Application No: K/17/22/PL
Site Address: Panorama Golden Acre Kingston BN16 1QP
Description of works: Conversion of existing 2 No flats into 1 No dwelling, single-storey extension with a sloping roof, new porch on ground floor, conservatory at first floor and roof extension, replacement of existing windows, doors and roof tiles. This site is in CIL Zone 4 and is CIL Liable as new dwelling.

Thank you for your internet representation made on 28th July 2022 which has been recorded as an objection with the comments as follows:

Drawing Title: Proposed Second Floor Roof Extension
Planning

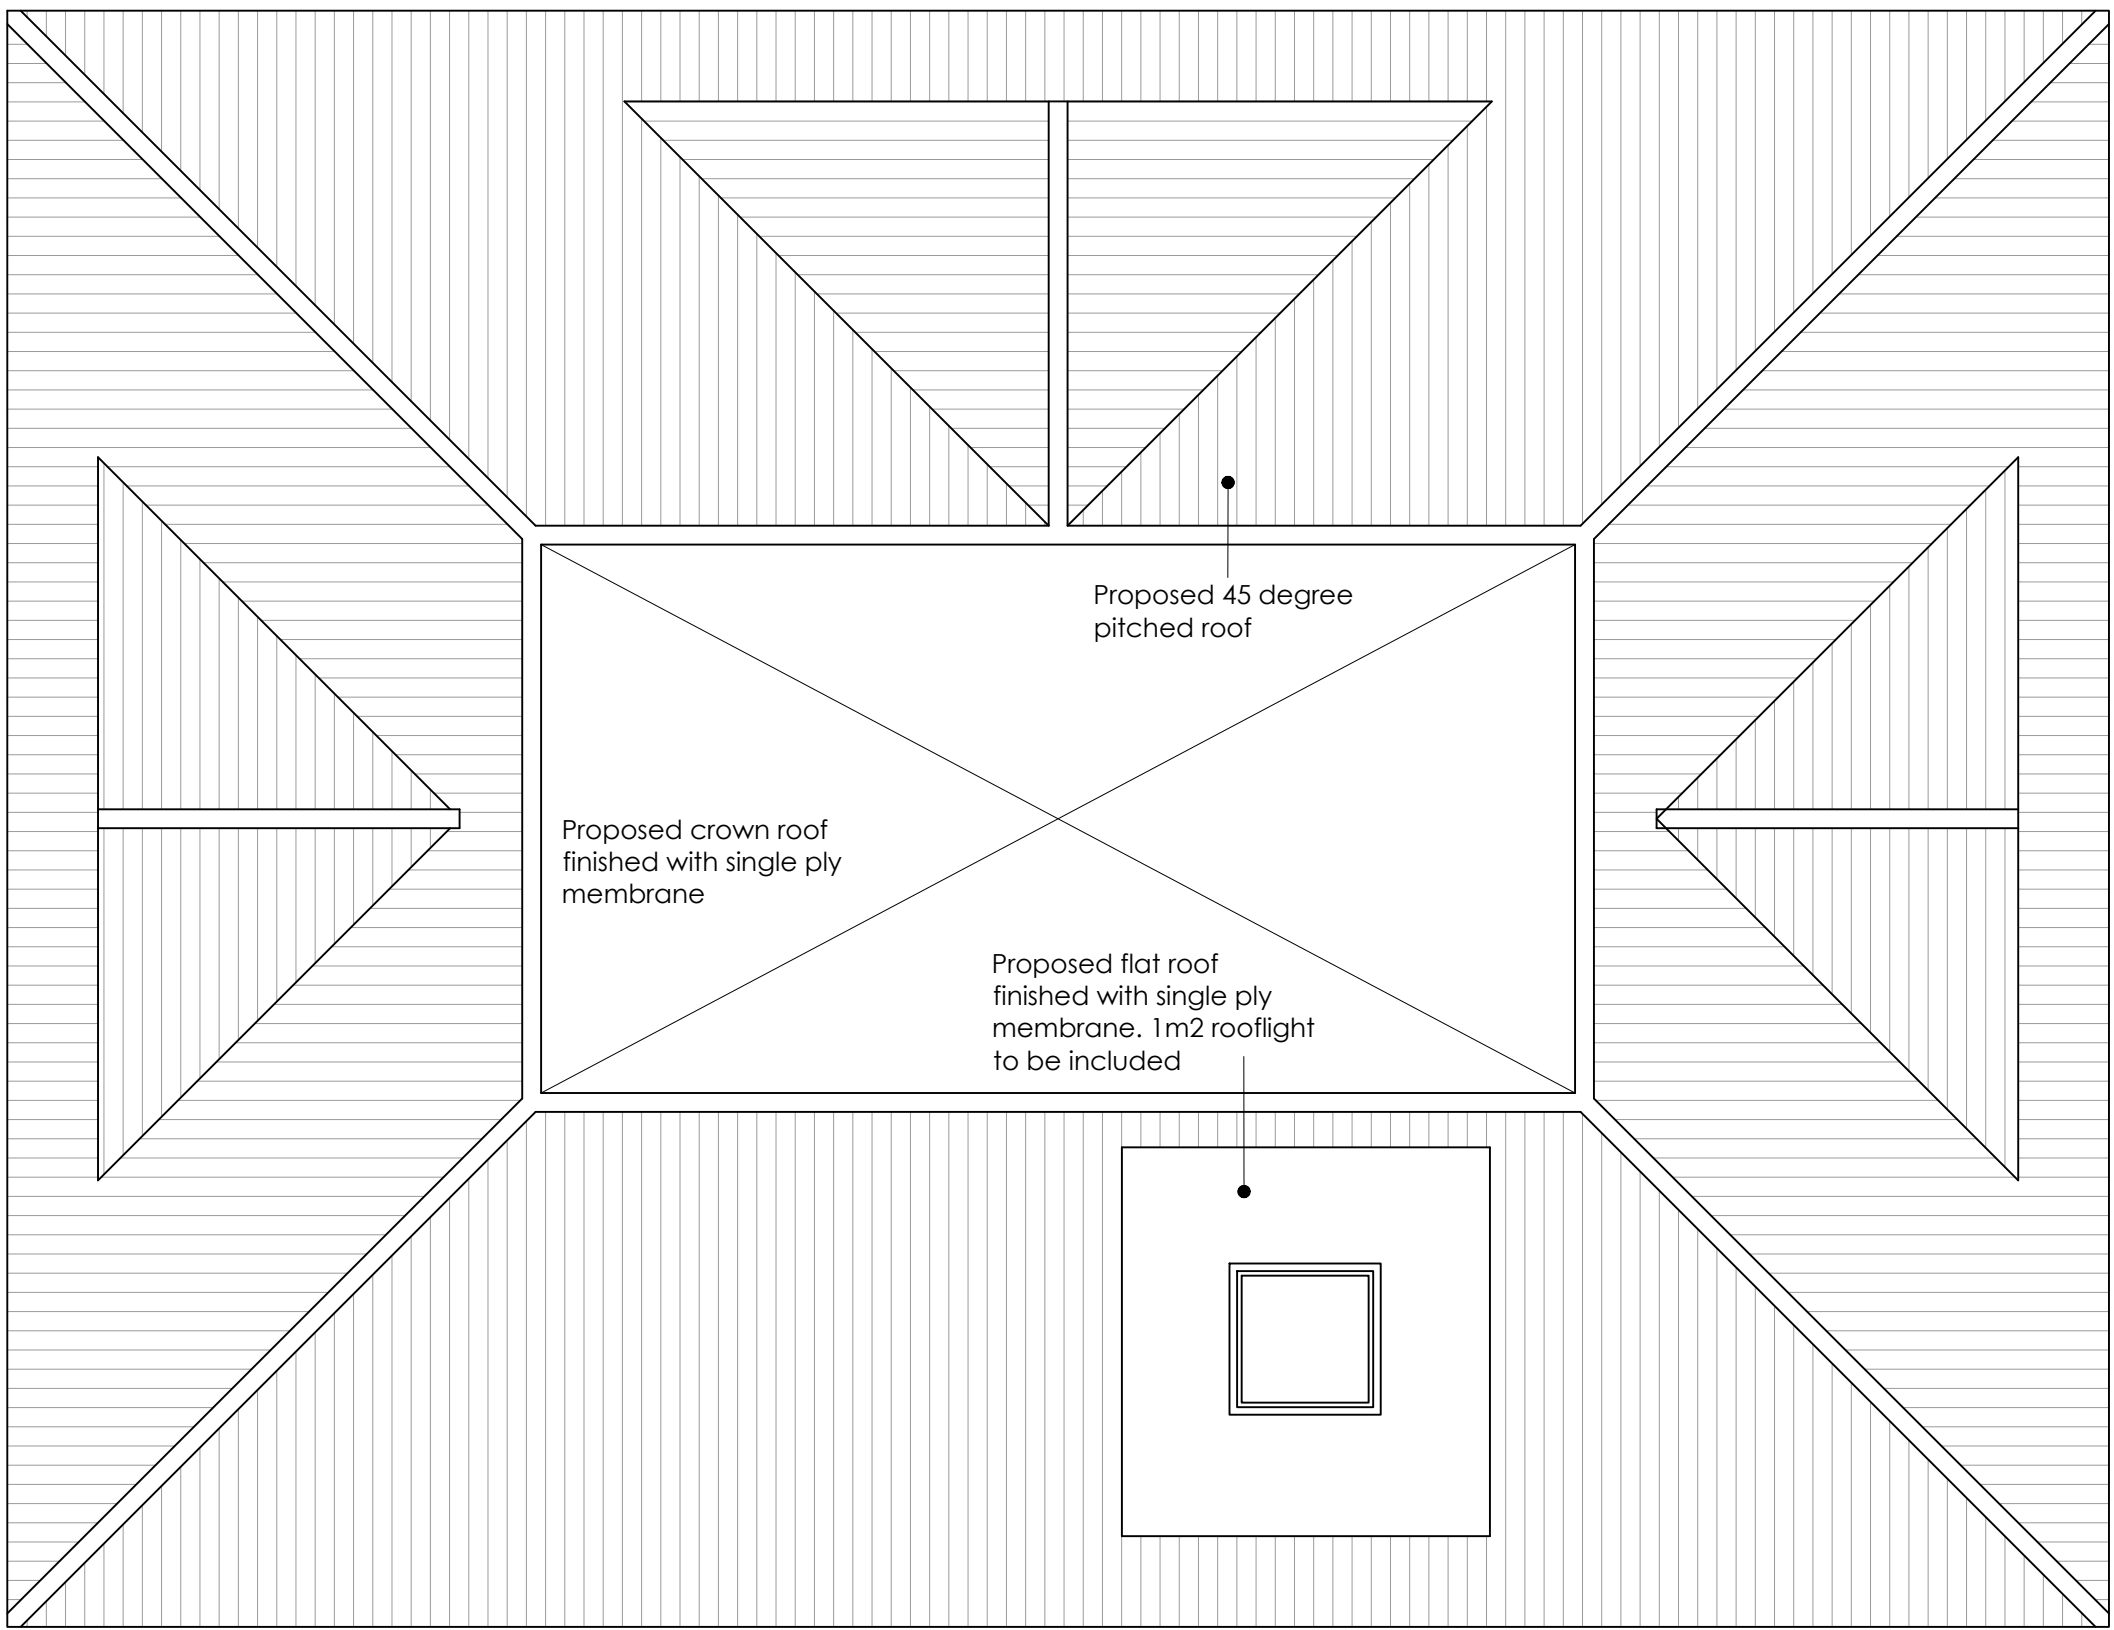
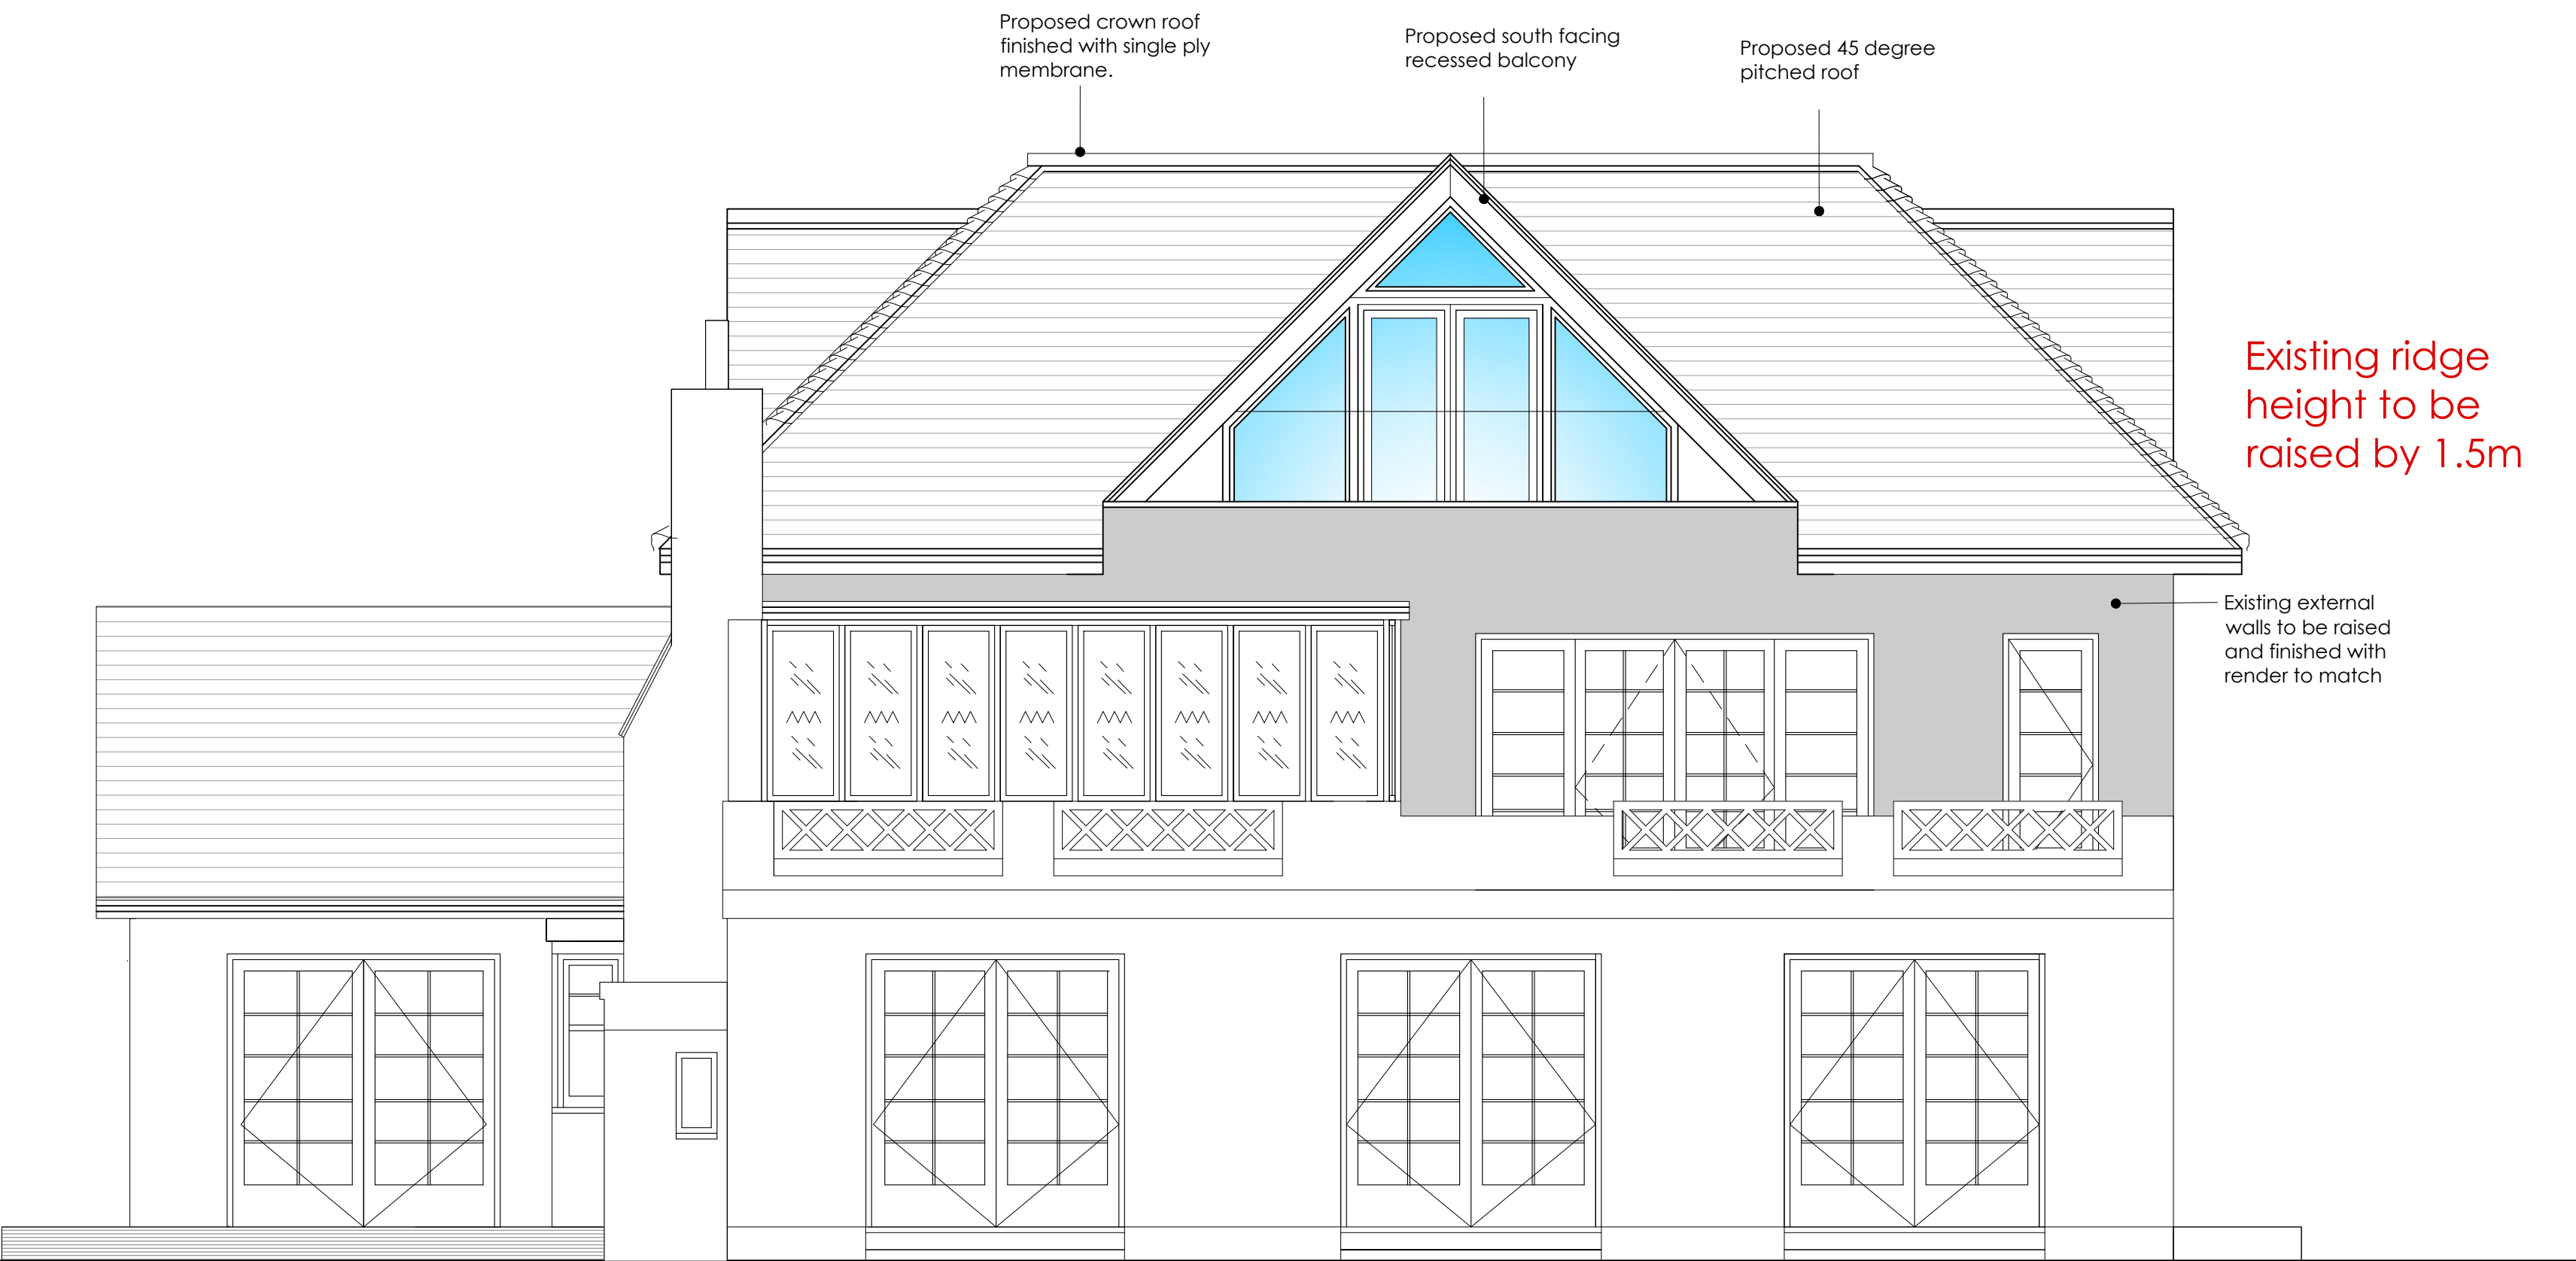
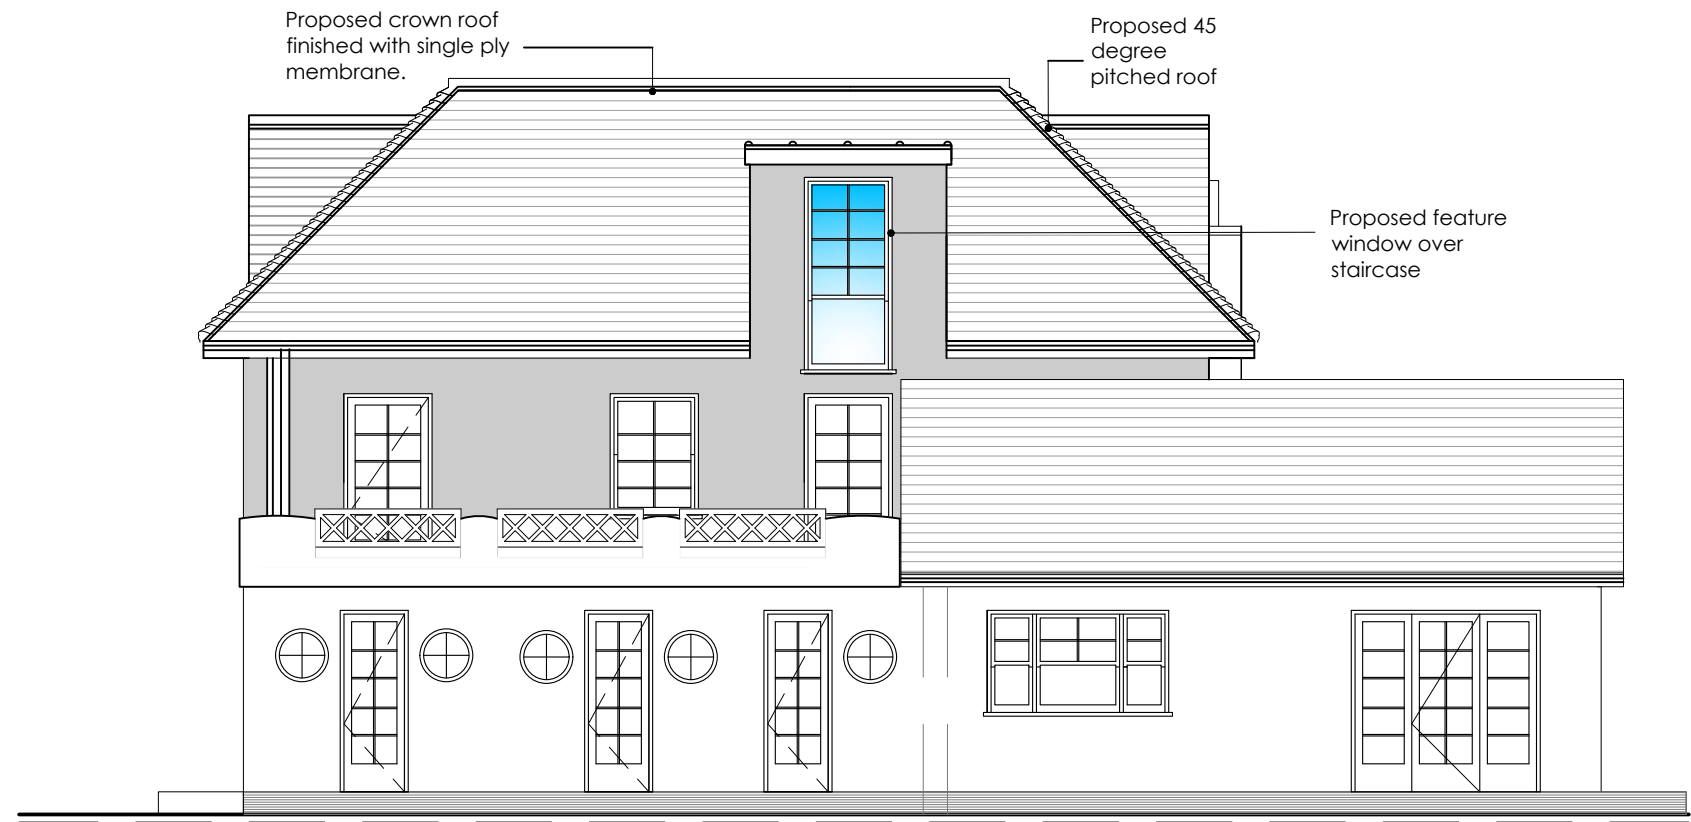
2. There needs to be an understanding of the impact the additionality of this development will have upon us. With the enlargement of the roof space and raised ridge height and the inclusion of both the east elevation and north elevation windows within the roof to create the second floor will lessen our privacy even further. The northerly elevation roof window will look directly down into our main bedroom that is on the south west corner of our property, let alone the eastern elevation roof windows that will expose the totally of our rear garden with
